KIRKLEES METROPOLITAN COUNCIL INVESTMENT & REGENERATION SERVICE

DELEGATED DECISION TO DETERMINE APPLICATIONS FOR CONSENT, AGREEMENT OR APPROVAL REQUIRED BY CONDITION

Reference No:	2025/44/92088/E
Site Address:	Land off, Bankwood Way, Birstall Retail Park, Birstall, Batley, WF17 9DT
Description:	Discharge of details reserved by conditions 9 (retaining walls) and 18 (Remediation Strategy) on previous permission 2024/91591 for variation of conditions 2-6, 15 and 29 of previous permission 2021/92528 for erection of retail development, associated parking, servicing areas and landscaping
Recommending Officer:	William Simcock

DECISION – Discharge of Condition – Split Decision

Project No: 24185-SDS-00-FP-DR-S-3400
 Revision: T4

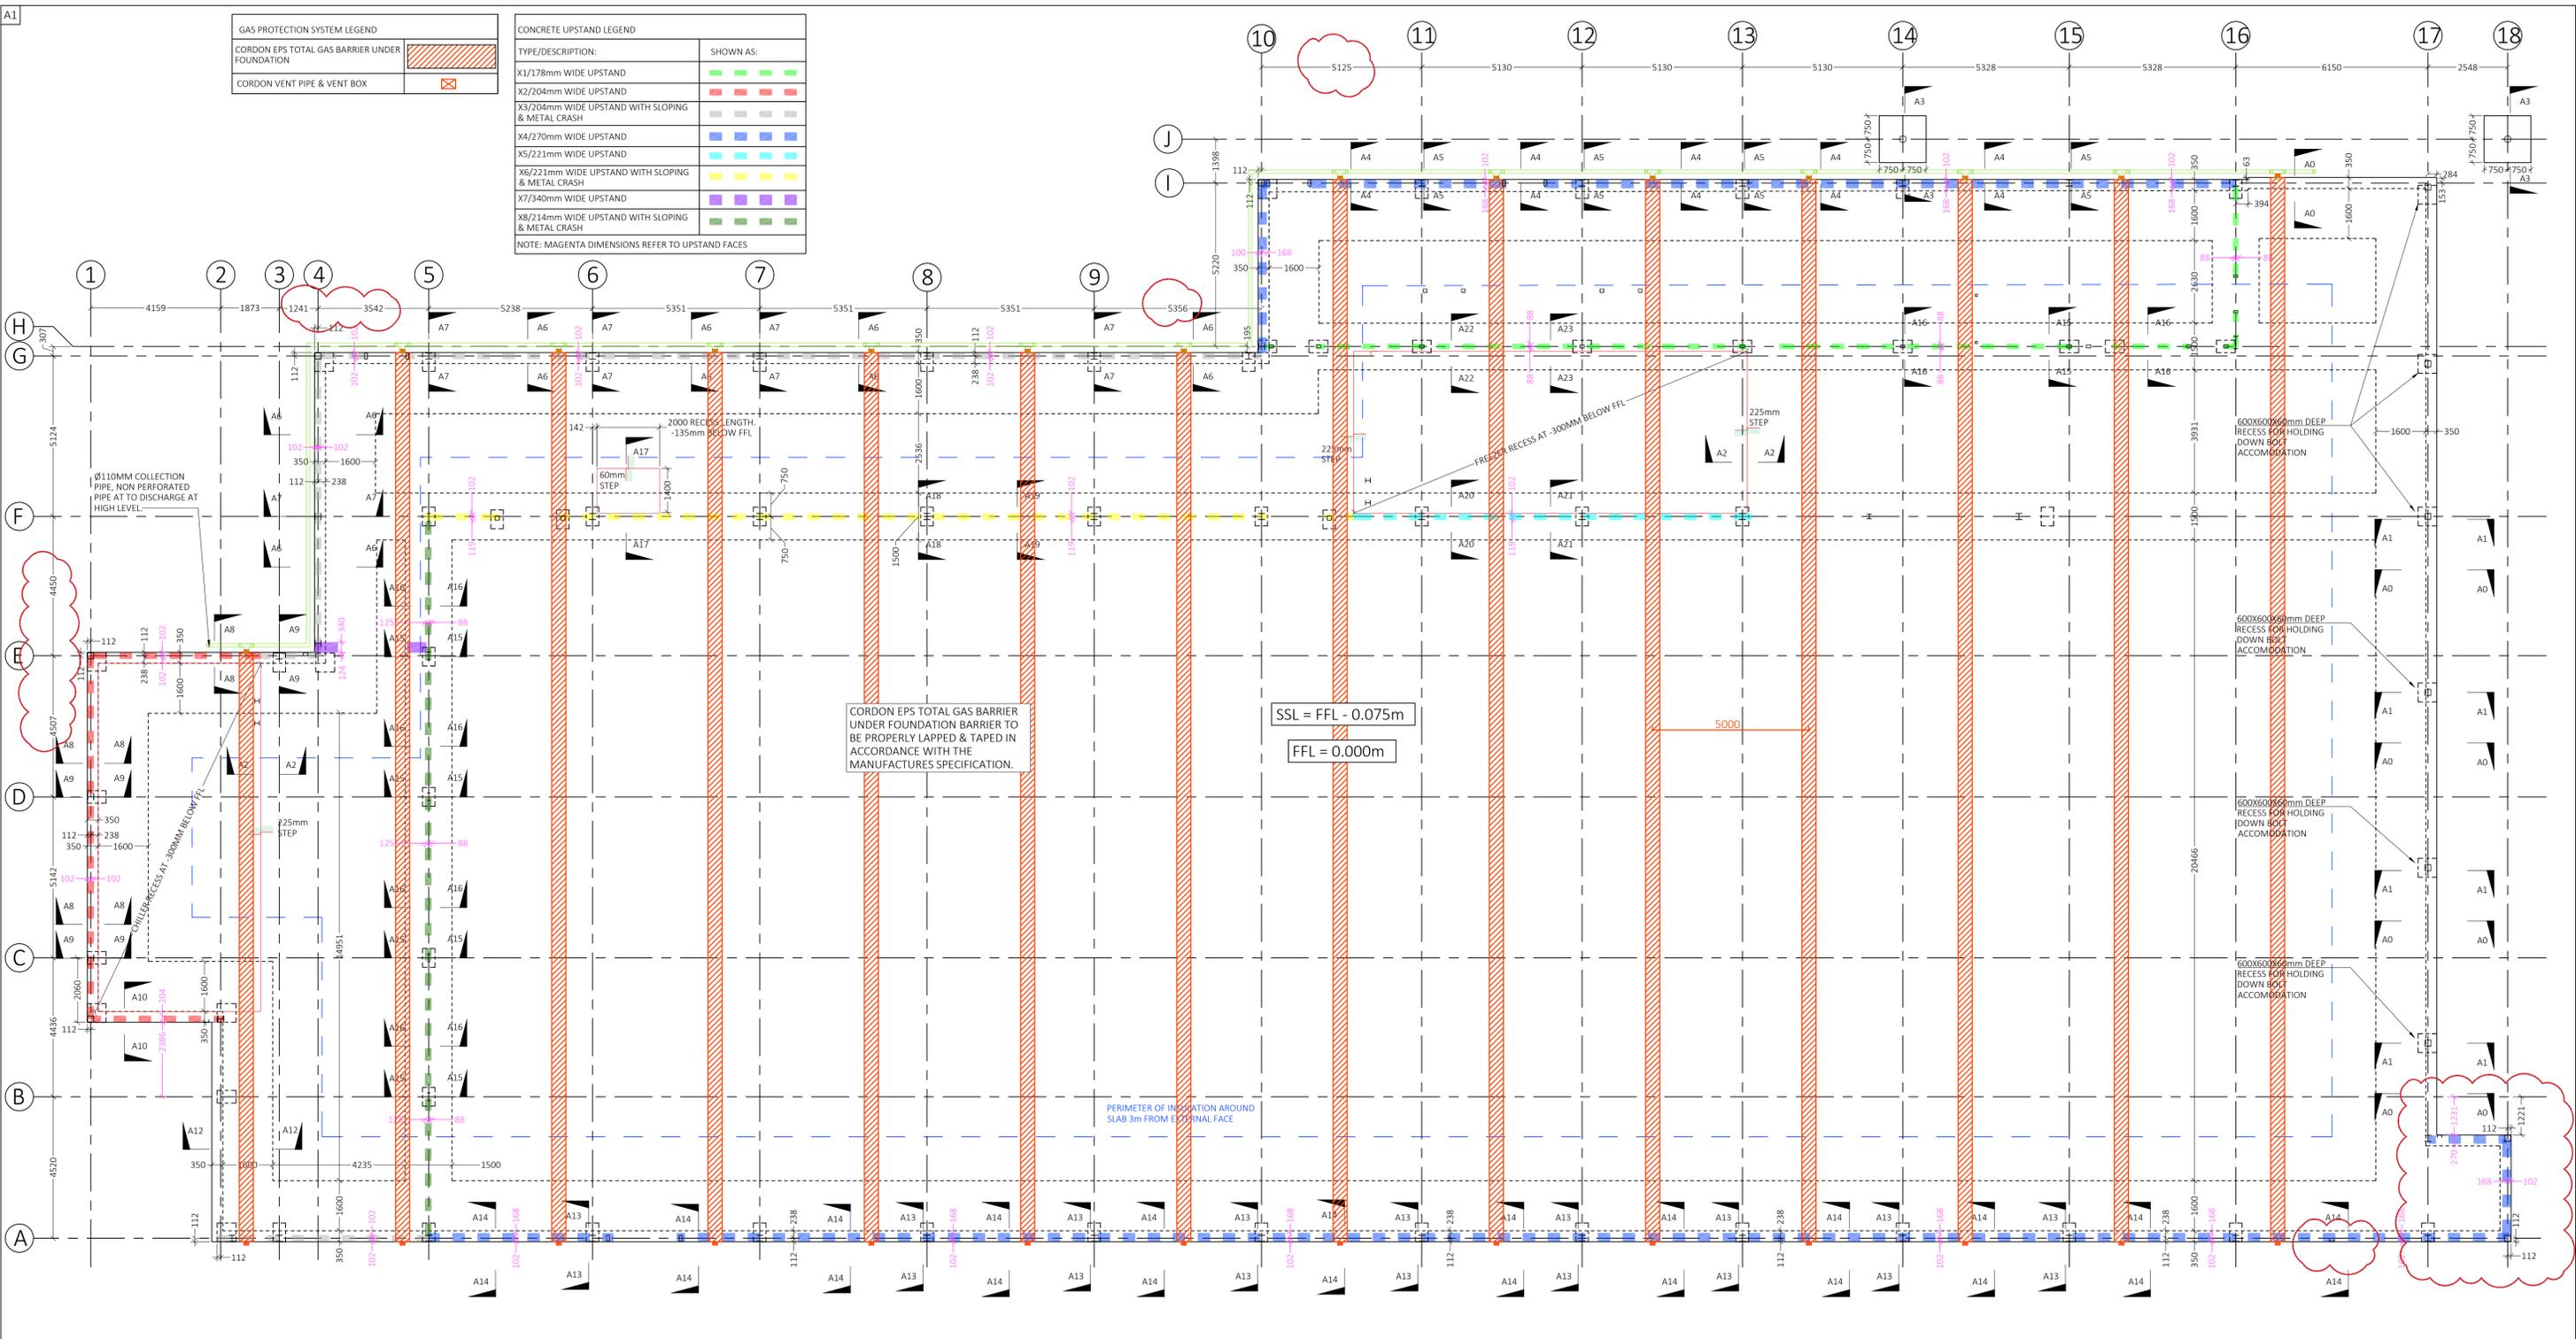
"Passive Sub-floor Dispersal Layer Details of the Passive Sub-floor Dispersal Layer are presented in the Structural Engineer's Drawing 24185-SDS-00-FP-DR-S-3400-T4 at Appendix D. The drawing specifies a Cordon EPS Total Gas Barrier with Cordon Vent and Pipe Box beneath the foundation. Cordon Product details are presented at Appendix E".
